**Application for a non-material amendment following a grant of planning permission.
Town and Country Planning Act 1990**

The consolidation of 15 existing units within the Pavilions shopping centre to create a single,large format retail unit, including reconfiguration works at basement level, insertion of new mezzanine floor and associated works at roof level.

Application for non-material amendment to planning permission 35214/APP/2014/2231

Drawing Title
MSU REDEVELOPMENT STAIR 4 / PLANT SCREEN ELEVATIONS

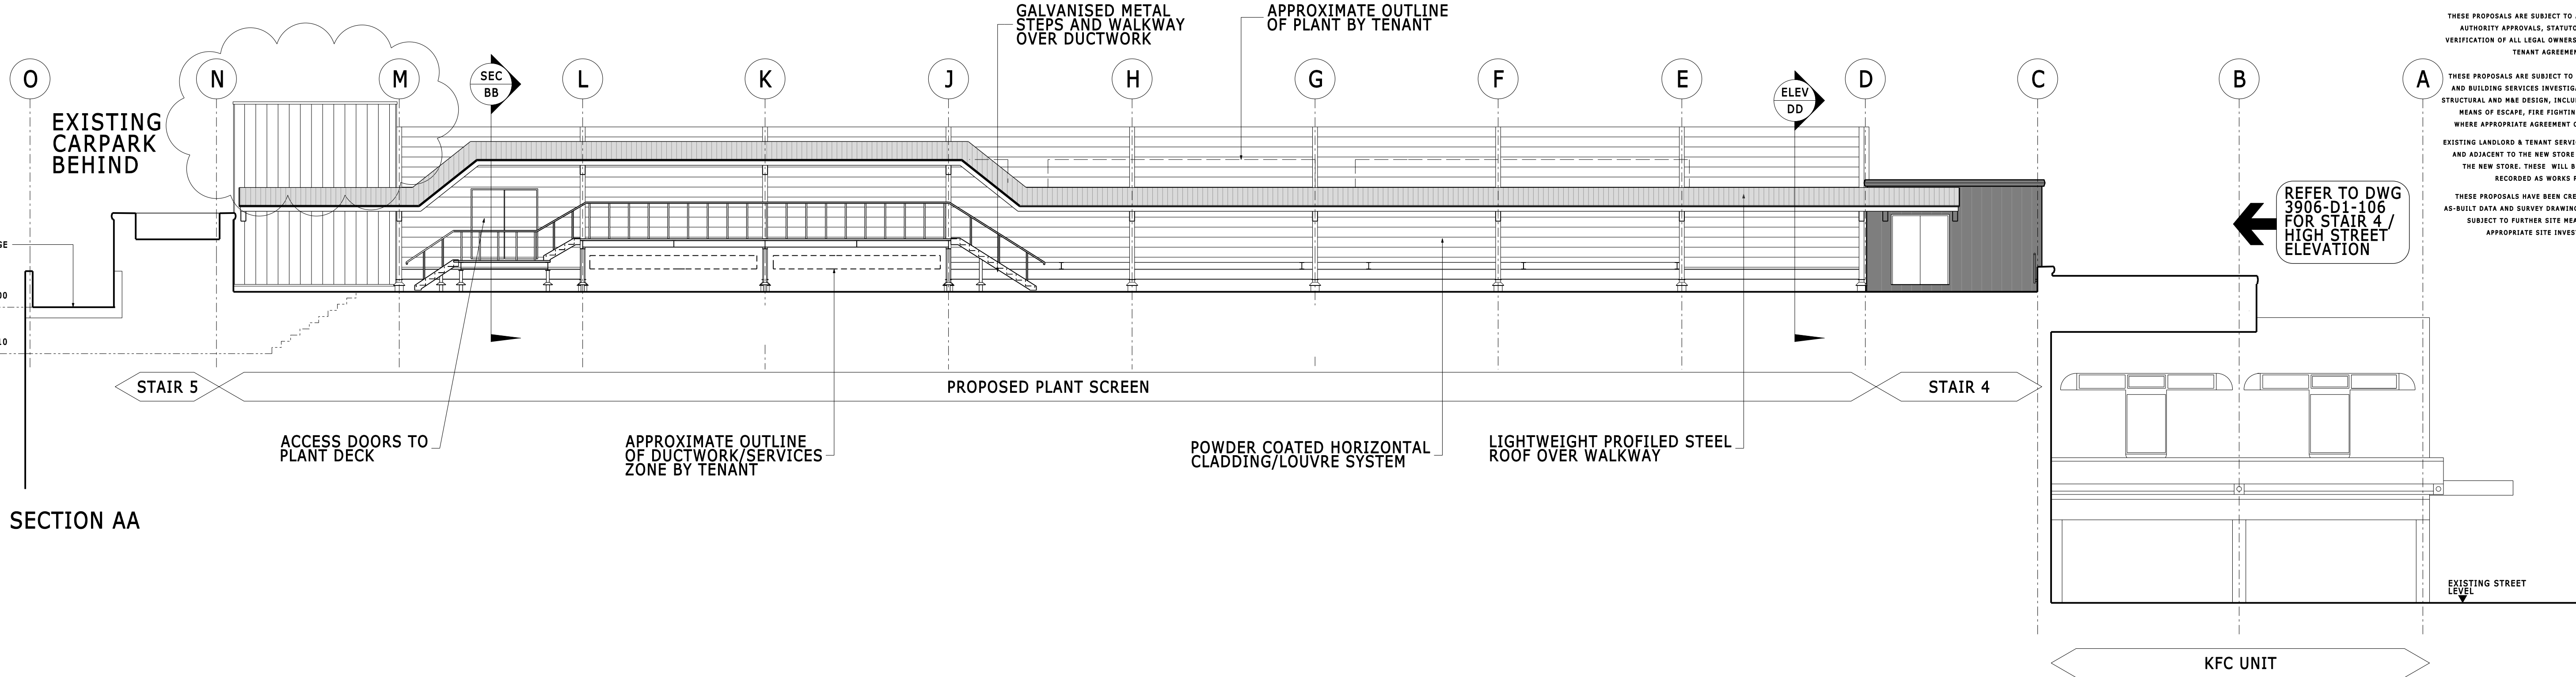
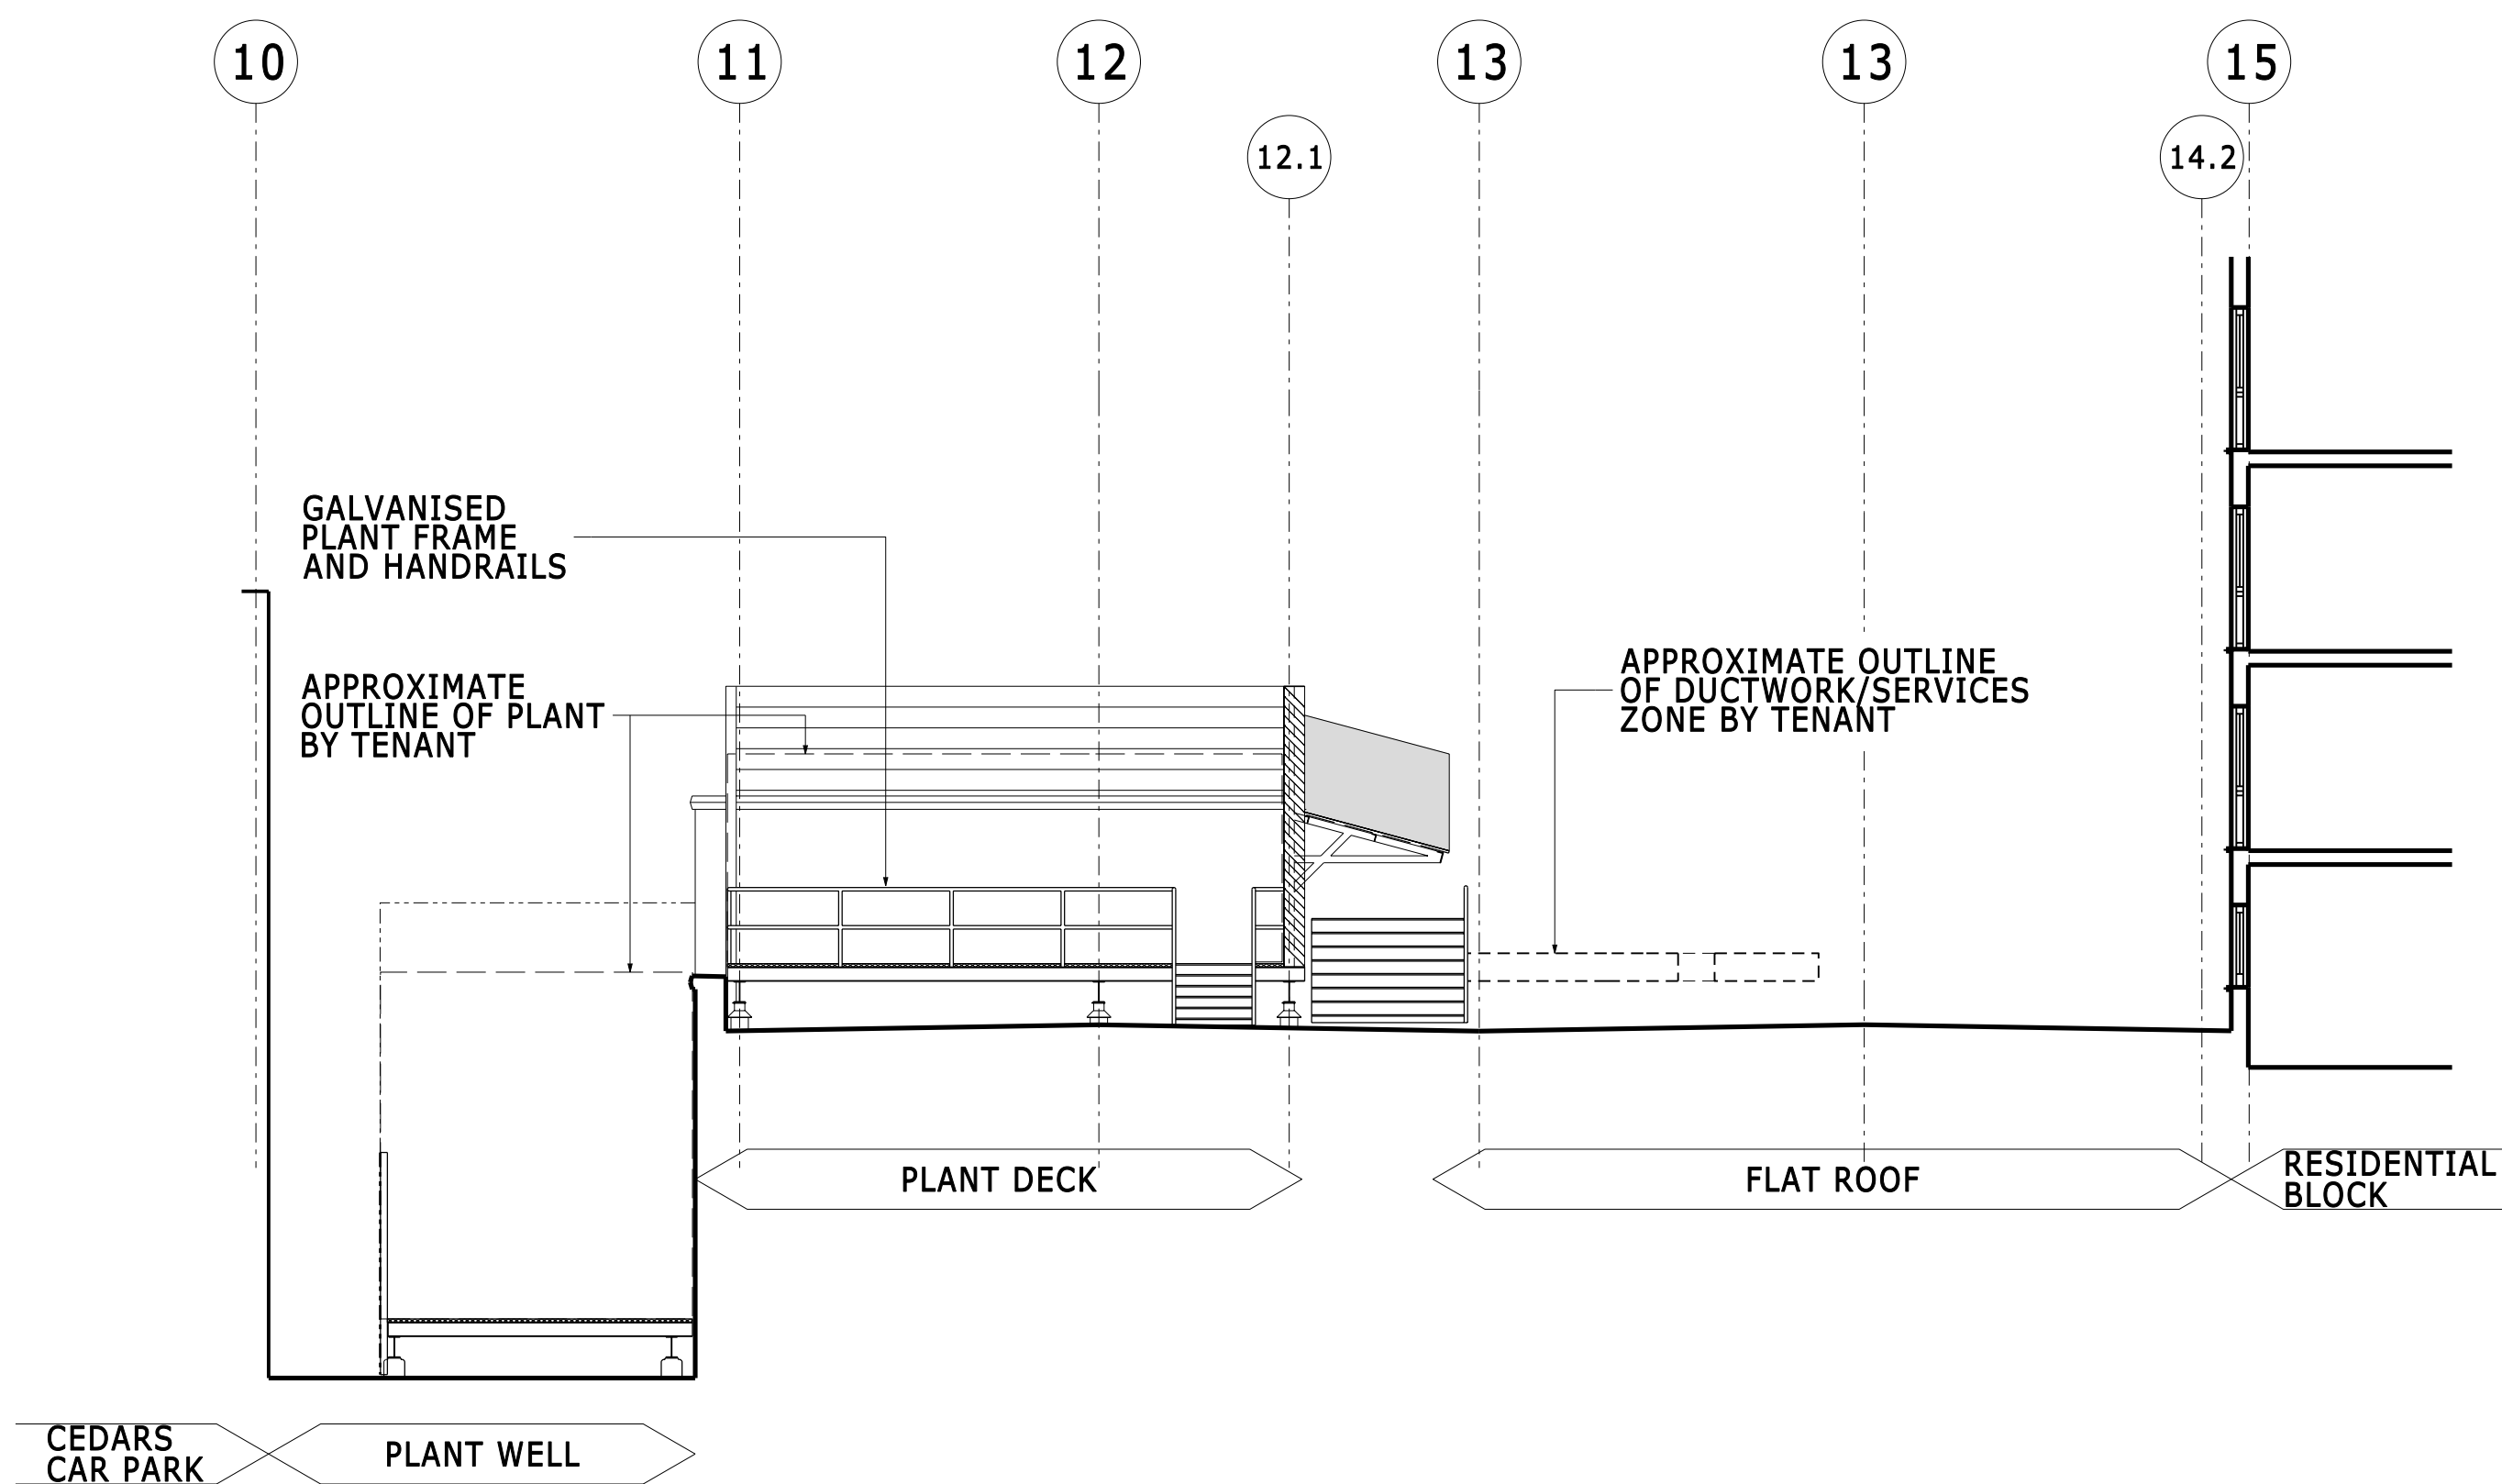
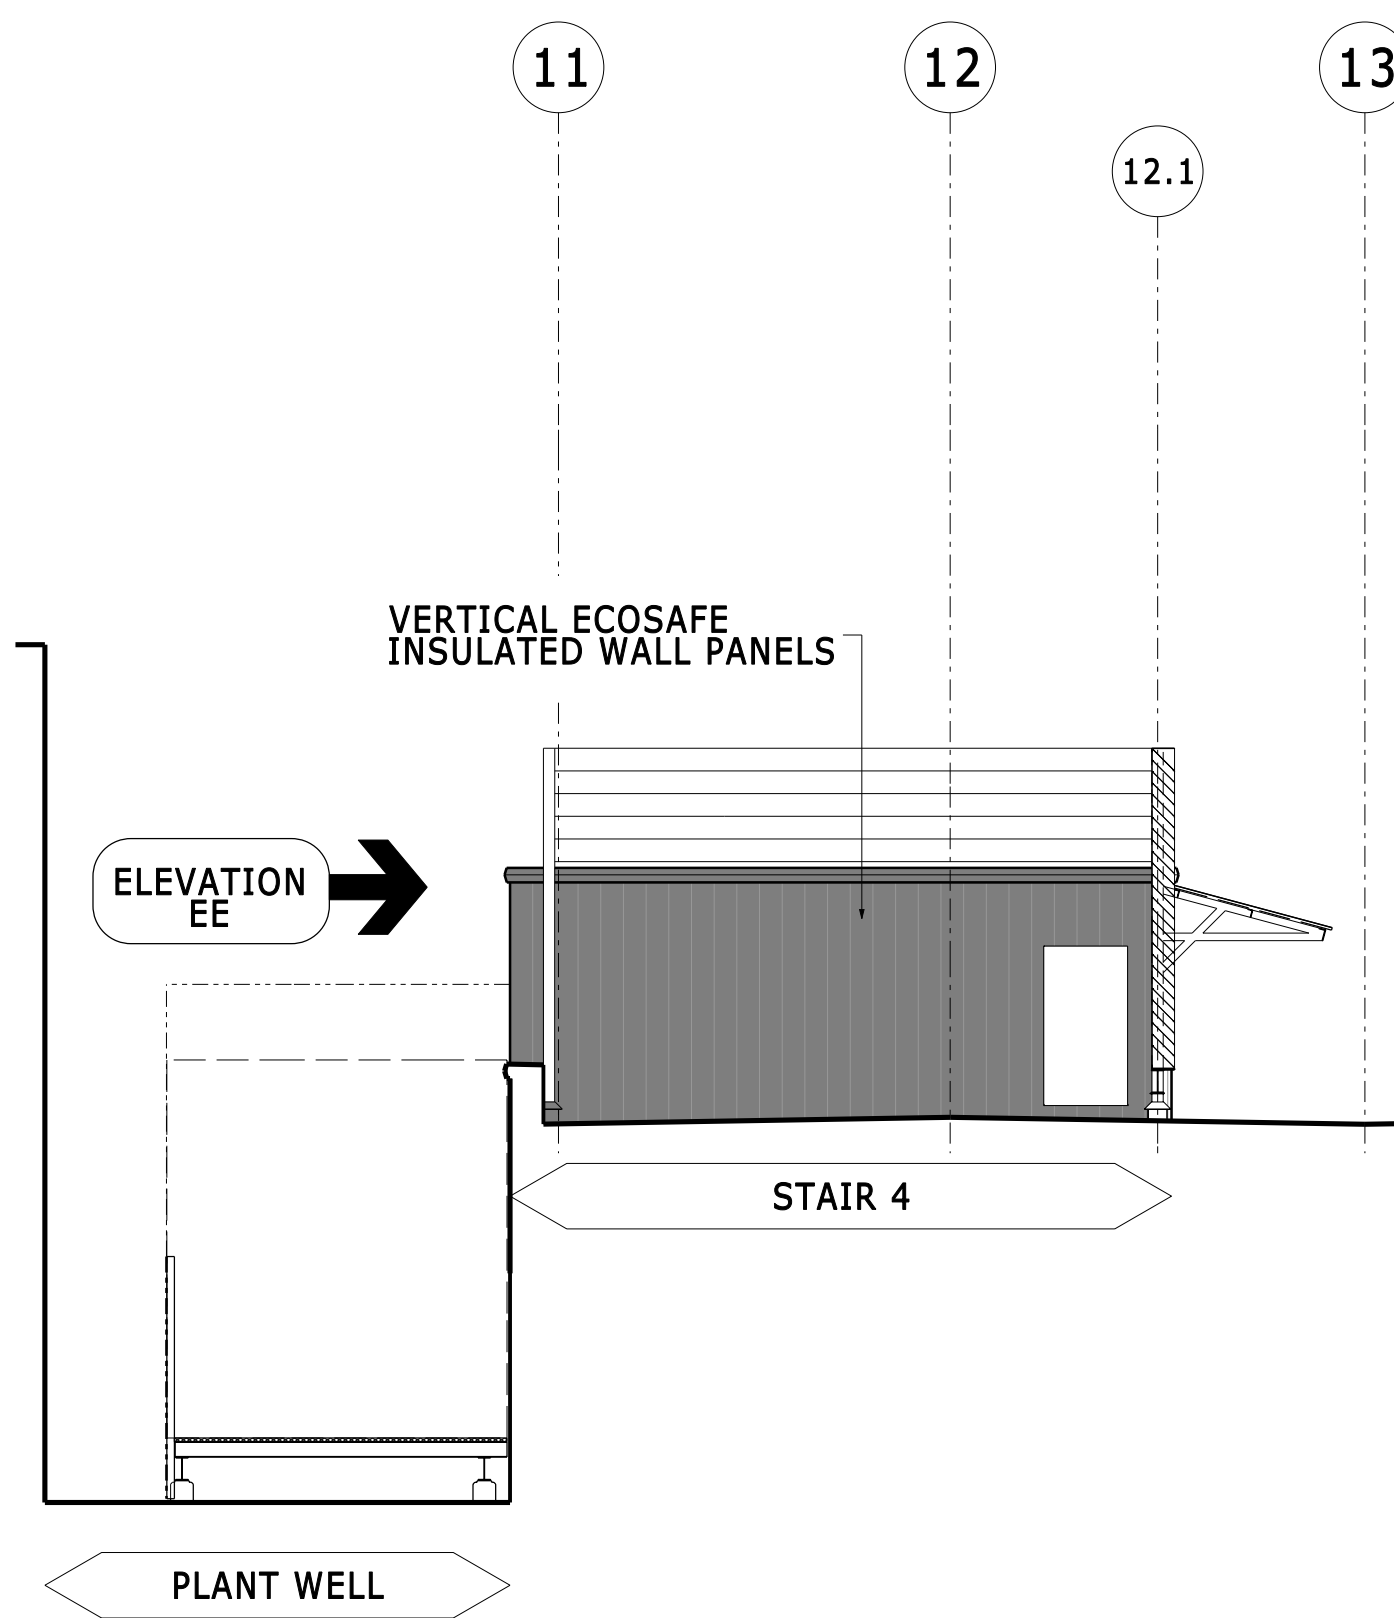
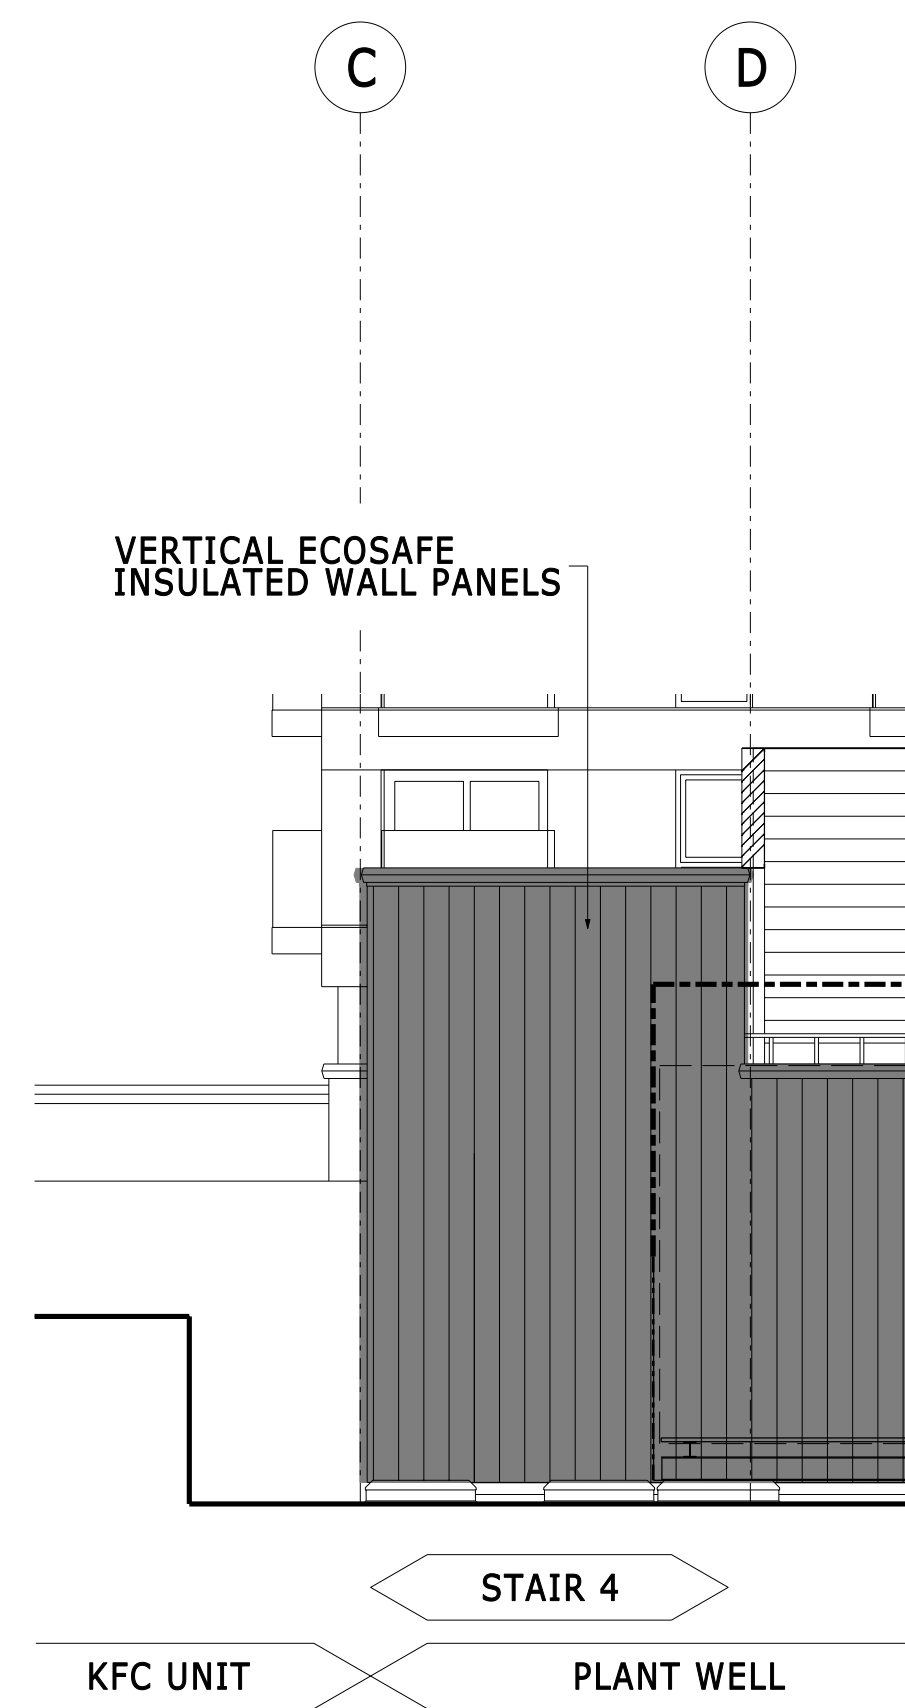
- For the relocation of 2 no. services riser on the new roof.
- For the extension of 1 no. lift, for service/ roof access to Tenant plant area.
- For the provision of a double access service door to replace the single door leaf on Grid Line 11.
